Fwd: Permit application 54 Ninth Street

I am in the process of reviewing your application to place an above-ground pool at 54 Ninth Street. As you are likely aware, the City of Portland's zoning code requires that pools be located at least 10 feet from both the rear lot line and the side lot lines. The plan you submitted in support of your application depicts the setback from the rear lot line but I can't tell how far away from the side lot lines the pool will be. Can you please send along those measurements so I can determine whether your application meets the City's code requirements?

POOL →  
LOCATION  
(SEE SKETCH)  
ATTACHED

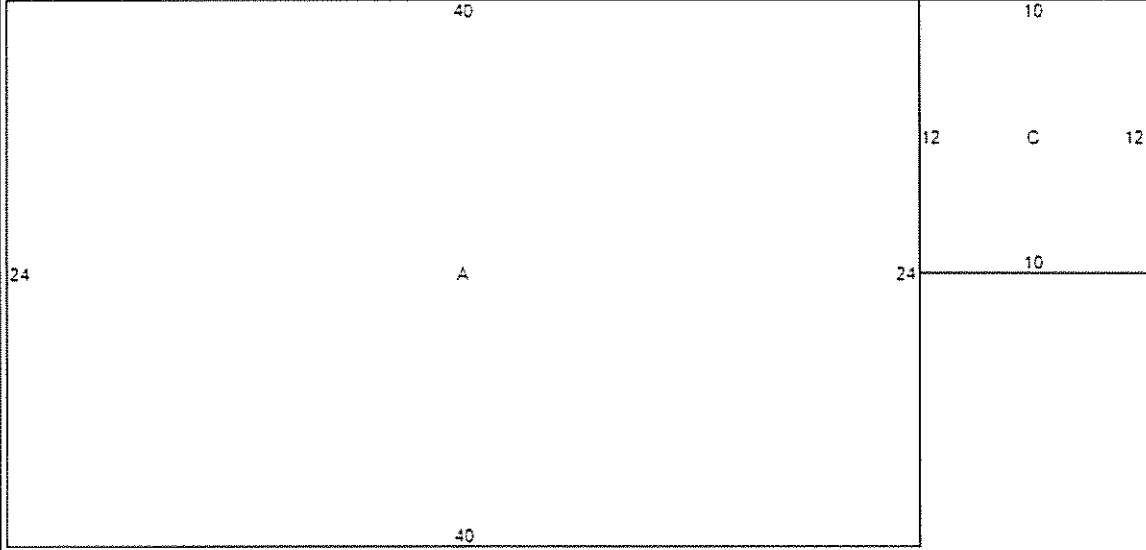
Thanks, Brian. This is helpful. I assumed there was sufficient distance but because the measurements on plan you sent aren't to scale, this confirmation will be helpful for our records. I appreciate your quick response.

My apologies Jennifer. I probably neglected to provide that info because the distance from the left and right side is quite a bit over 10 ft from the property line. The distance on the left side is 18 feet and the right side is 35 feet. I updated the picture in case you need that as well to replace the original.
